From: [REDACTED]
Sent: 12 July 2024 11:46
To: Planning
Cc: [REDACTED]
Subject: Application No. 3/2024/0393 Land adjacent to no 9 Old Road Chatburn BB7 4AB
Attachments: Application 3_2023_0866 - Land adjacent to 9 Old Road Chatburn BB7 4AB - [REDACTED]
[REDACTED]

Retaining Wall

'Construction Method Statement', 'CEMP Plan', 'Construction Phase Plan'

PROJECT		DRAWING TITLE	
PLOT 11 HARE HILL CROFT, CHATBURN OLD ROAD		CONSTRUCTION MANAGEMENT	
CLIENT	MR R JACKSON	SCALE	1:1
DATE	APR 23	JOB REF	001
DRN BY	AM	DRAWING NUMBER	PLOT11DOCCEMP
WKS	@A1	REV	B

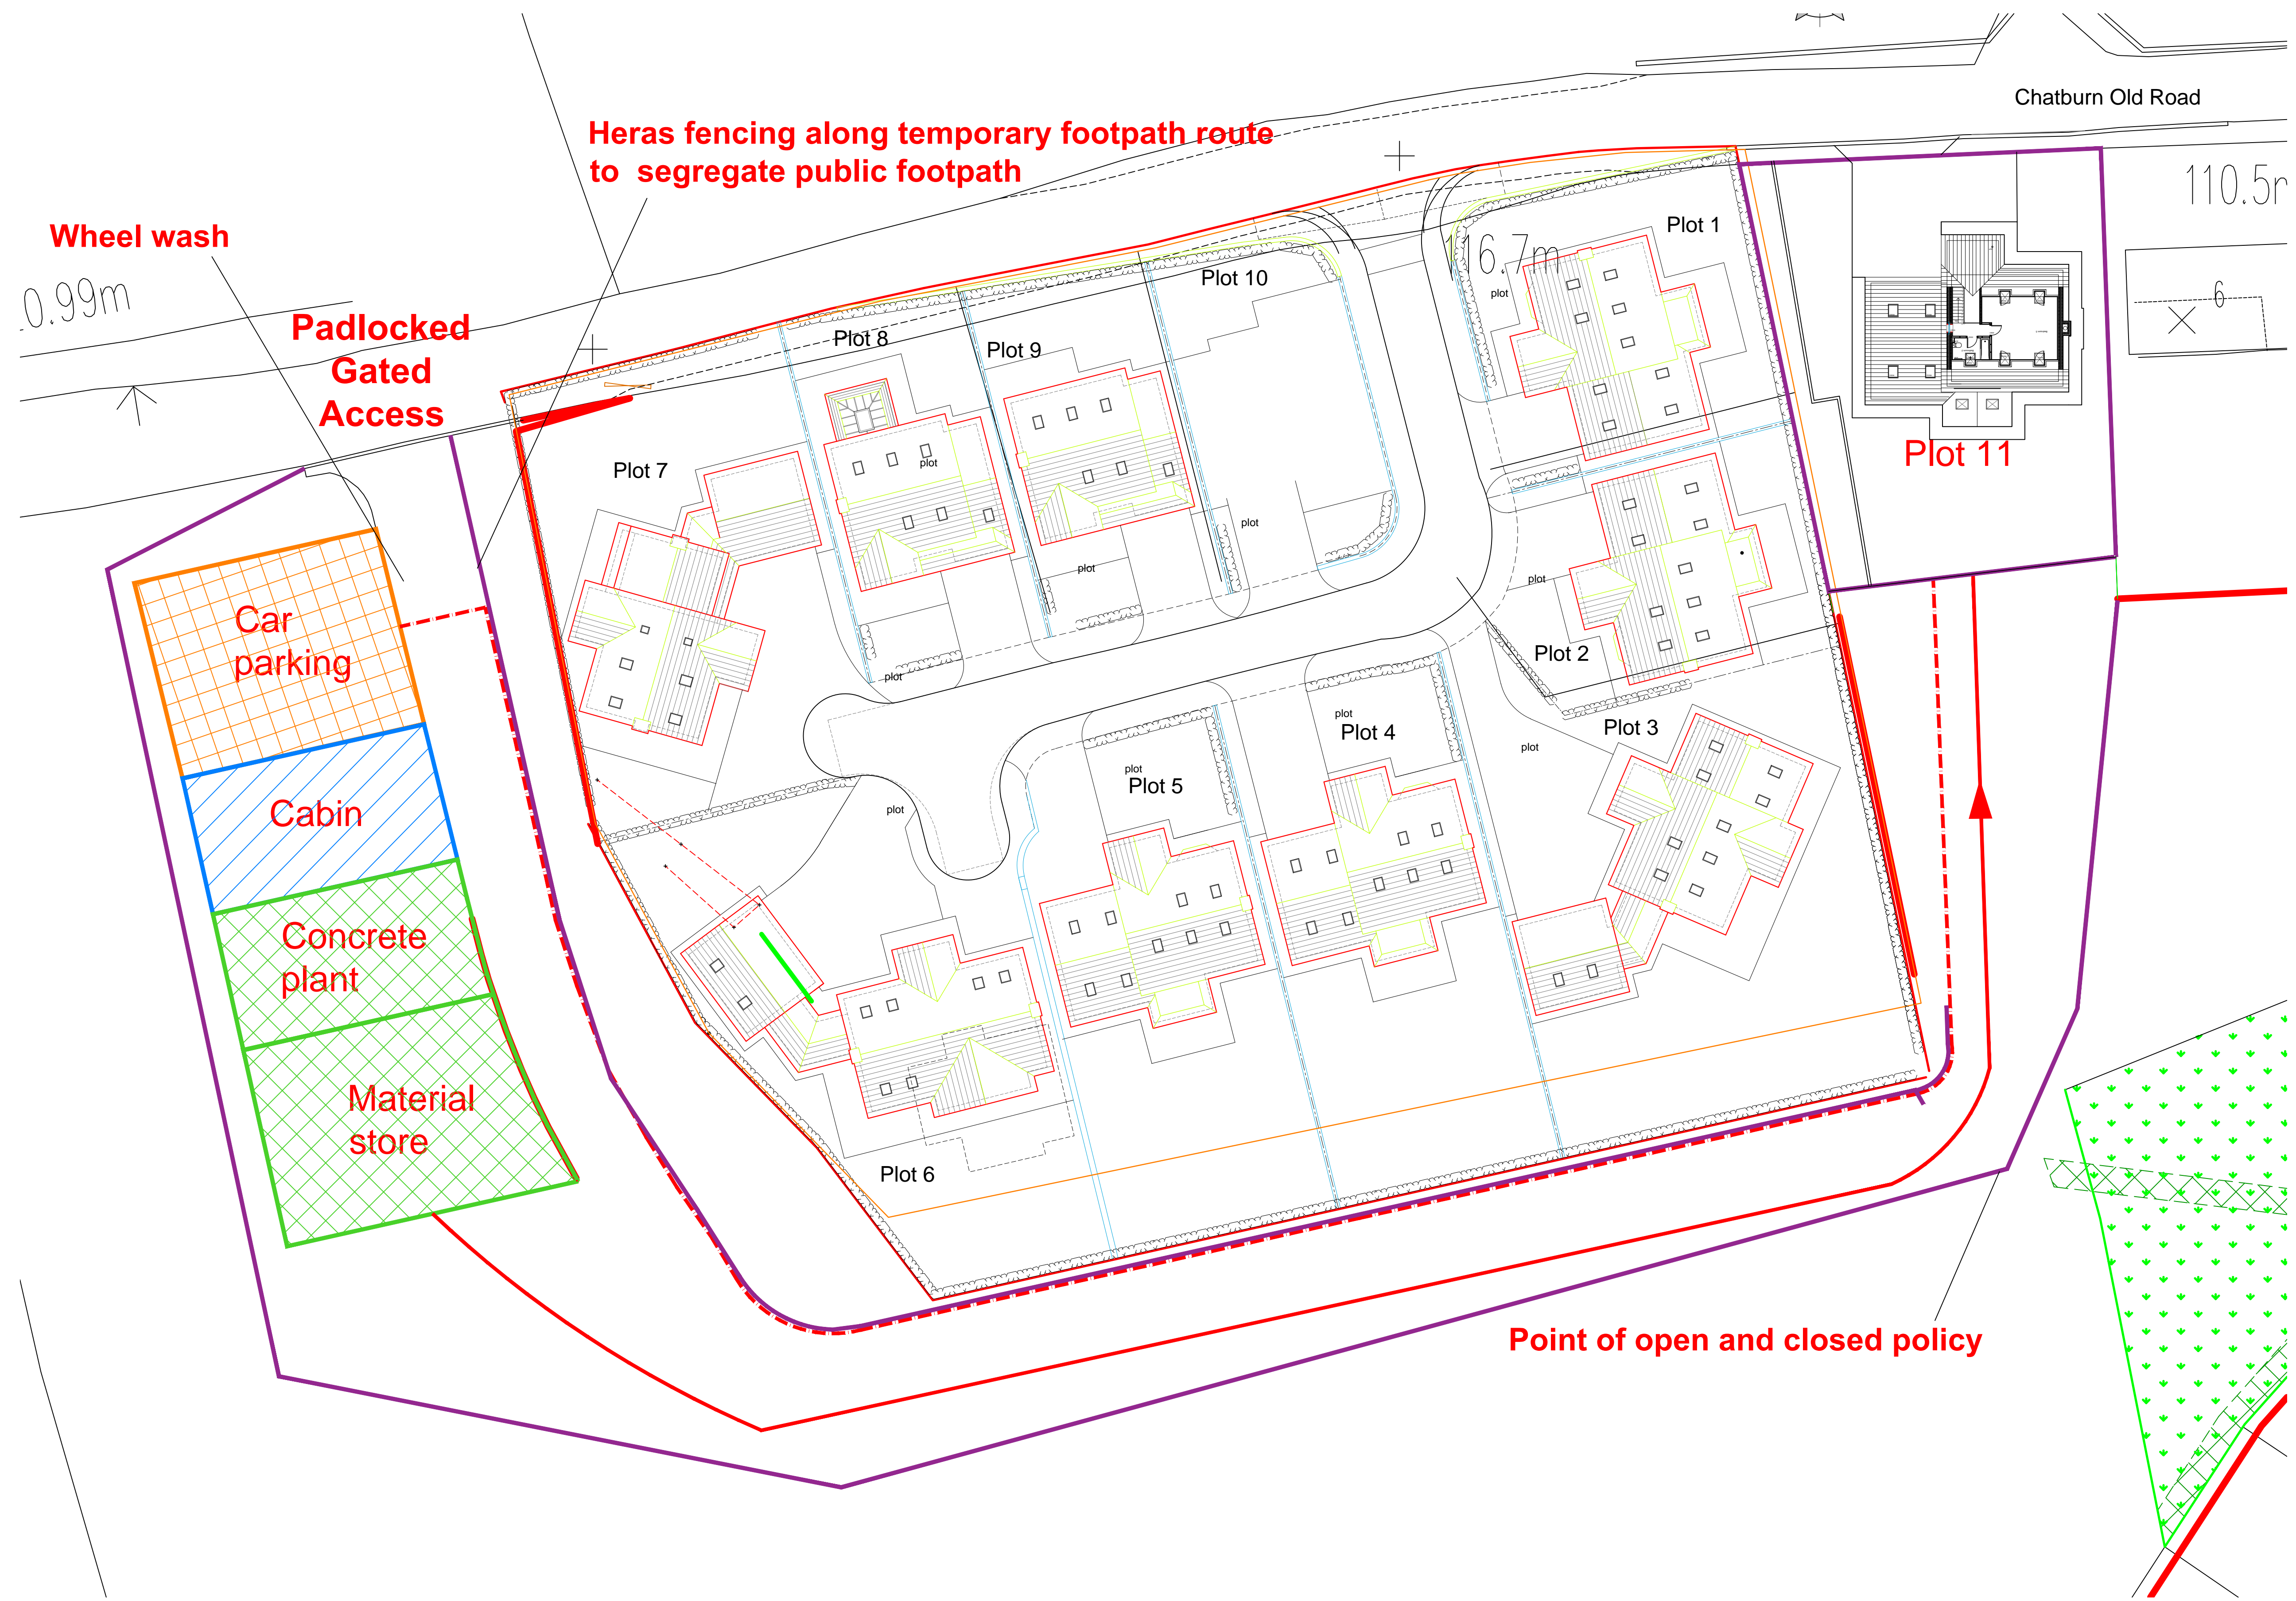
1. The proposals for access and construction are contrary to the conditions within the approved planning permission and will inevitably increase the level of disruption and nuisance to all of the residents of HHC along the access route.

2. The proposed access route shown on the attached plan along the boundary of 3 (part),4,5,6,7 Hare Hill Croft (HHC) has already been constructed without planning permission.

3. The proposed compound shown on the attached plan lies on land that should have, by now, been reinstated back to its original condition, in line with the requirements of the HHC planning permission following the completion of HHC.

6. There are no levels on the attached plan that allow you to assess the scale of excavation required to get from current levels to the lower levels of the proposed dwelling. There would inevitably need to be a ramp from the access route as shown on the plan, in order get down to the lower levels and construct the proposed dwelling.

7. The access route is shown as one-way on the plan, see comment on reversing below.
8. The landscape plan shows shrubs along land that does not belong to the developer along the boundary for No.2 HHC, plus there is a c.5m drop in levels between the edge of the landscaping width along the HHC boundary and the proposed dwelling.

9. If permission is granted the gates either side of the footpath shown on the plan need to be locked when not in use as public could access the working area.

- (ii) Regarding the statement *“There will be no reversing off site, vehicles will turn around at the site materials storage areas and then exit site onto Old Road.”* There should be no reversing on site along the haul road also as the noise of reversing vehicles is extremely disturbing. In order to avoid reversing you need to be able to turn around at the proposed dwelling area. None of this is shown on the plan and in reality there isn't space to turn around next to the site of the dwelling.

TITLE: PLOT 11 - Chaburn Old Rd  
Westerly retaining wall detail

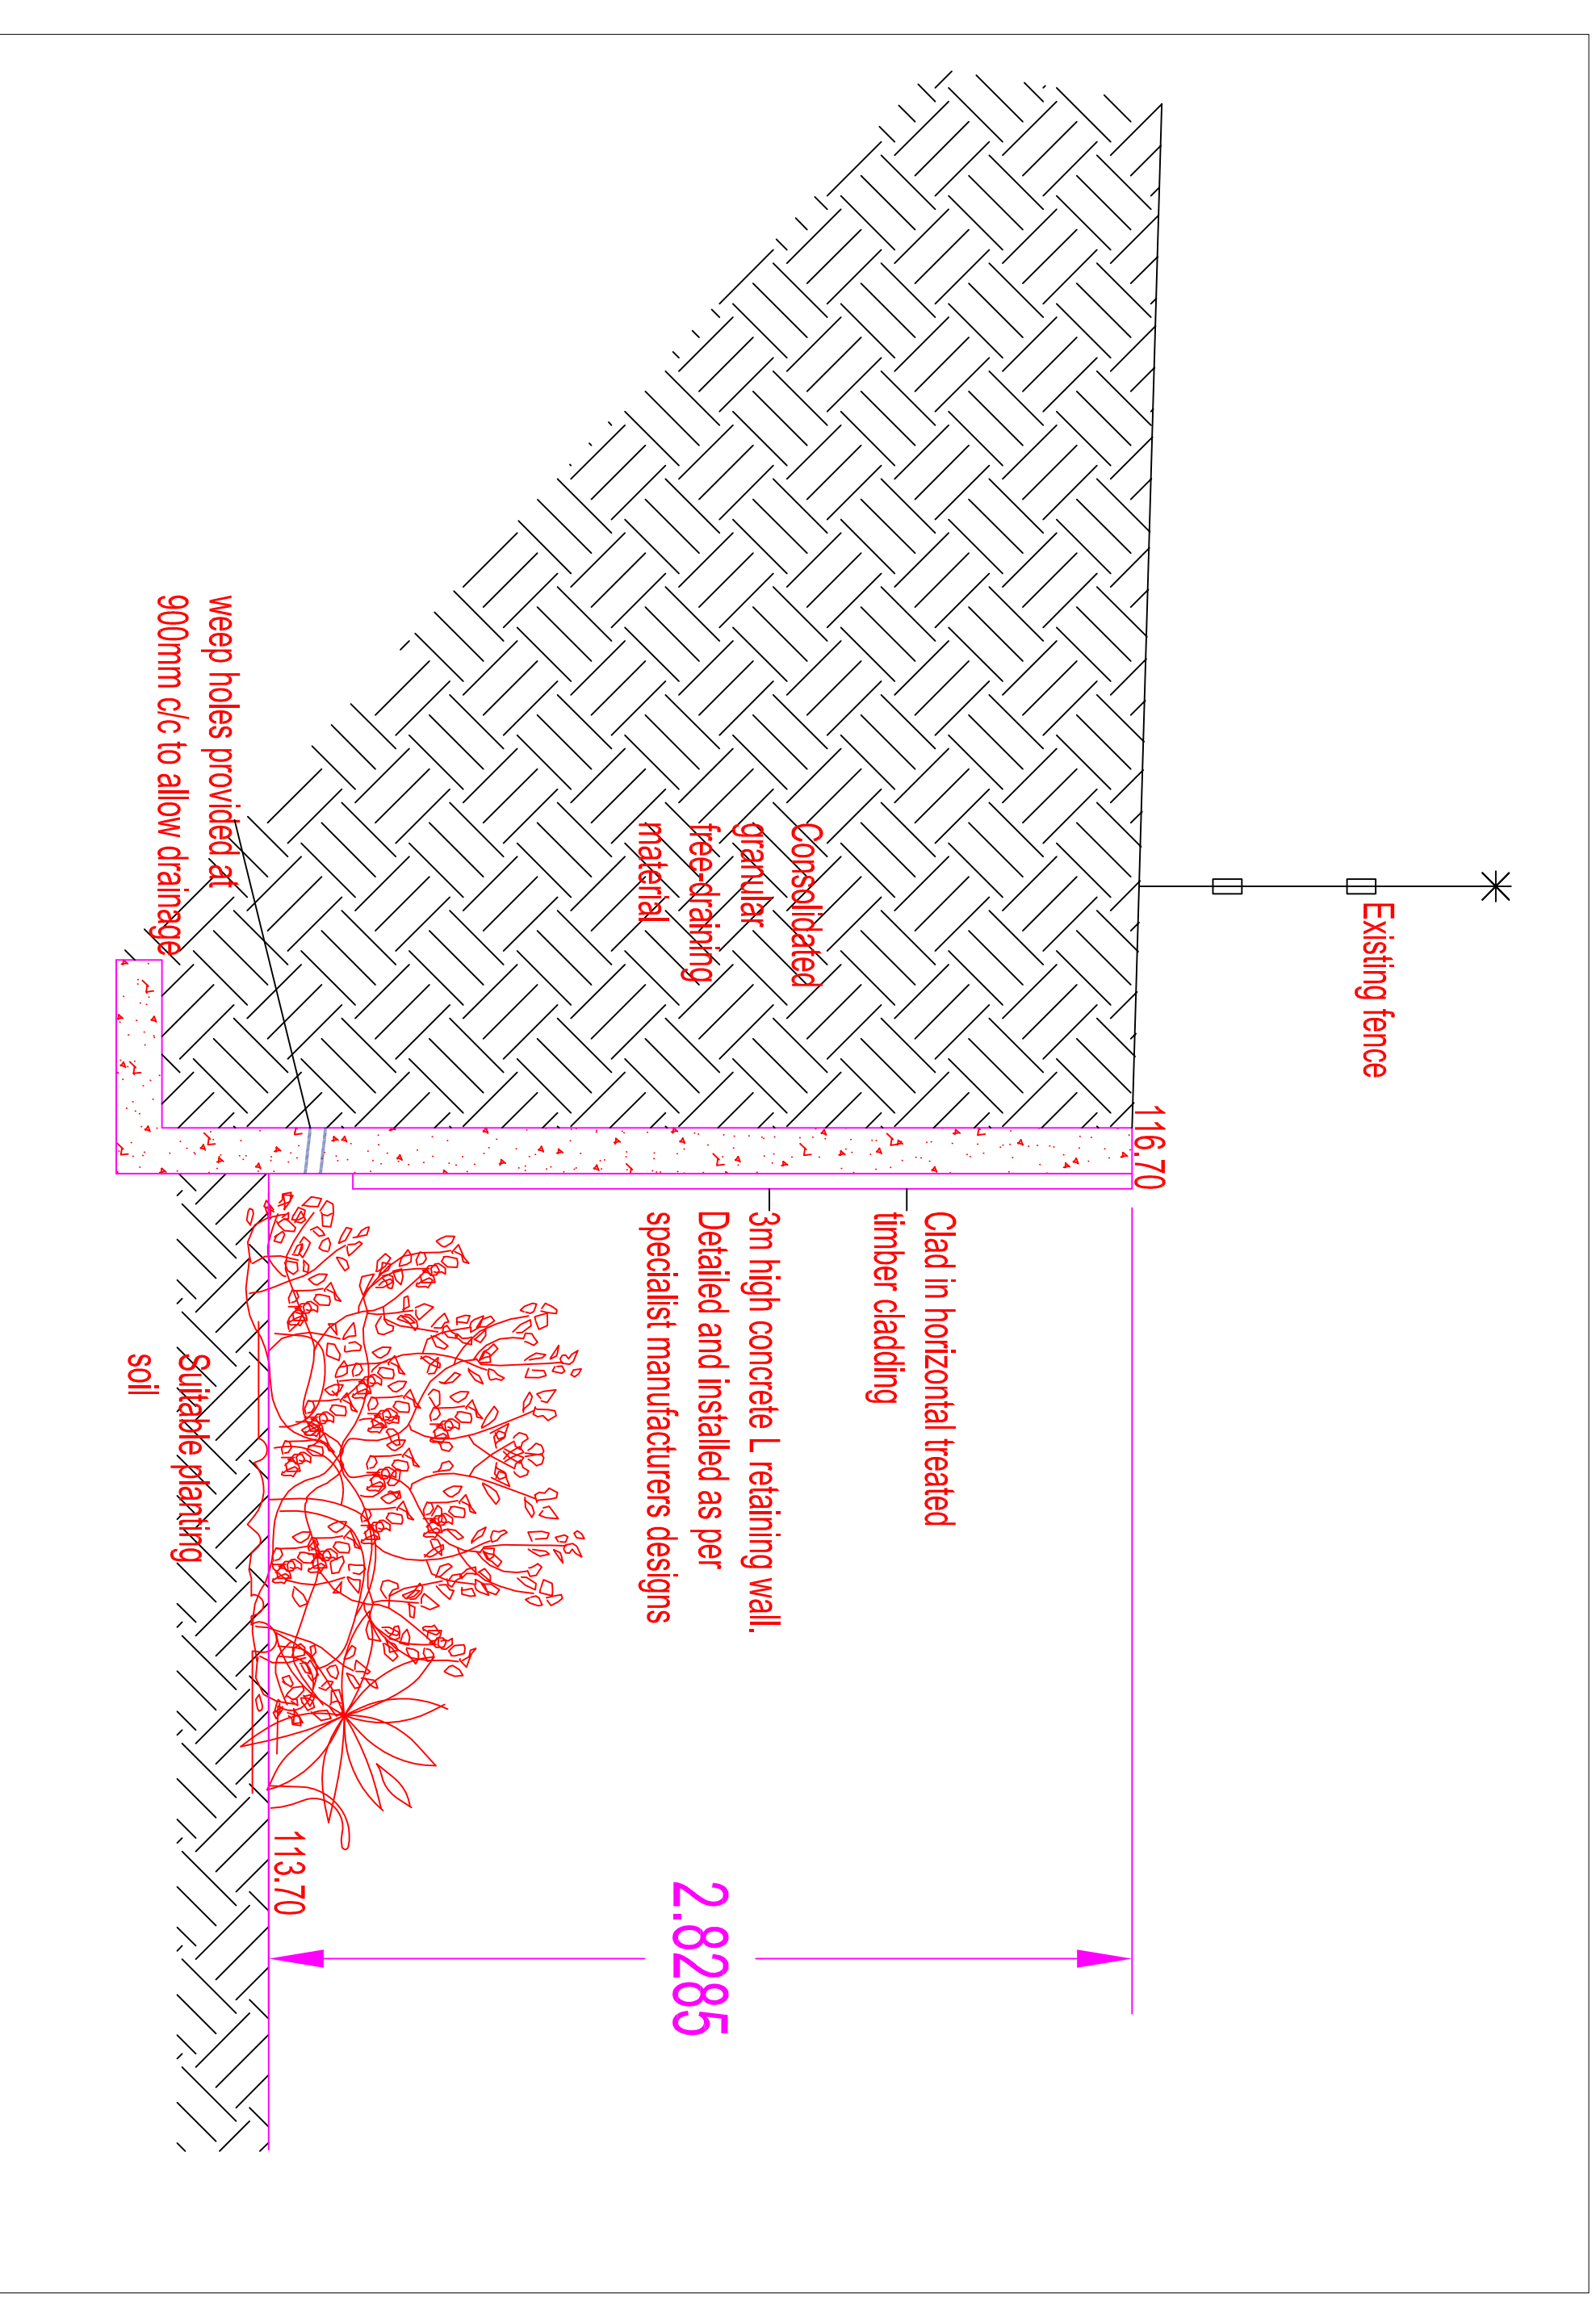
The details shown on the proposed 'westerly retaining wall detail' drawing 'COR/Plot11/WRW' are misleading in that the foundation (the horizontal base part of the 'L' shape) is far too short. The reality of the detail as drawn is that you would need to bolt down the short base to a large foundation slab below the 'L', which is not shown on the drawing. Alternatively, the horizontal element of the 'L' would need to be much wider and encroach beyond the red line boundary. If you were minded to consult a professional Civil or Structural Engineer they would no doubt reach the same conclusion as I have.

It is clear from the proposals shown on drawing 'COR/Plot11/WRW' that a significant encroachment into land area associated with No.2 Hare Hill Croft is required, which would need permission from the adjacent and, for the reasons noted below, some form of legal agreement.

Other important retaining wall design related matters that affect both the adjacent landowner(s) and the future owners of the new property would include:

- (i) Surcharge loading (applied load at ground level once the retaining wall has been constructed) on the high side of the retaining wall beyond the red line boundary. This imposes new restrictions on the use of adjacent land beyond the red line boundary.
- (ii) The Hare Hill Croft surface water drainage is conveyed into a reasonably large area of buried soakaway system in the rear gardens of the HHC properties. The proposed area of encroachment (excavation and fill) will inevitably connect the soakaway drainage to the new retaining wall design, which will alter the intended drainage function of the HHC properties.
- (iii) Drainage of the proposed retaining wall is noted as being through weep pipes. Any drainage system needs to be fully maintained over its life and would need taking into account with the proposed drainage plan for the new property.

- (iv) You could design the retaining wall to withstand the full hydrostatic head of water (no drainage), but this would make the structure even larger.
- (v) Design life of the proposed design needs careful consideration in the wider design life of the development and adjacent property context.

Assuming there will be no agreement with adjacent landowners the design of the proposed retaining wall would need to clearly demonstrate how it can be constructed within the red line boundary area.
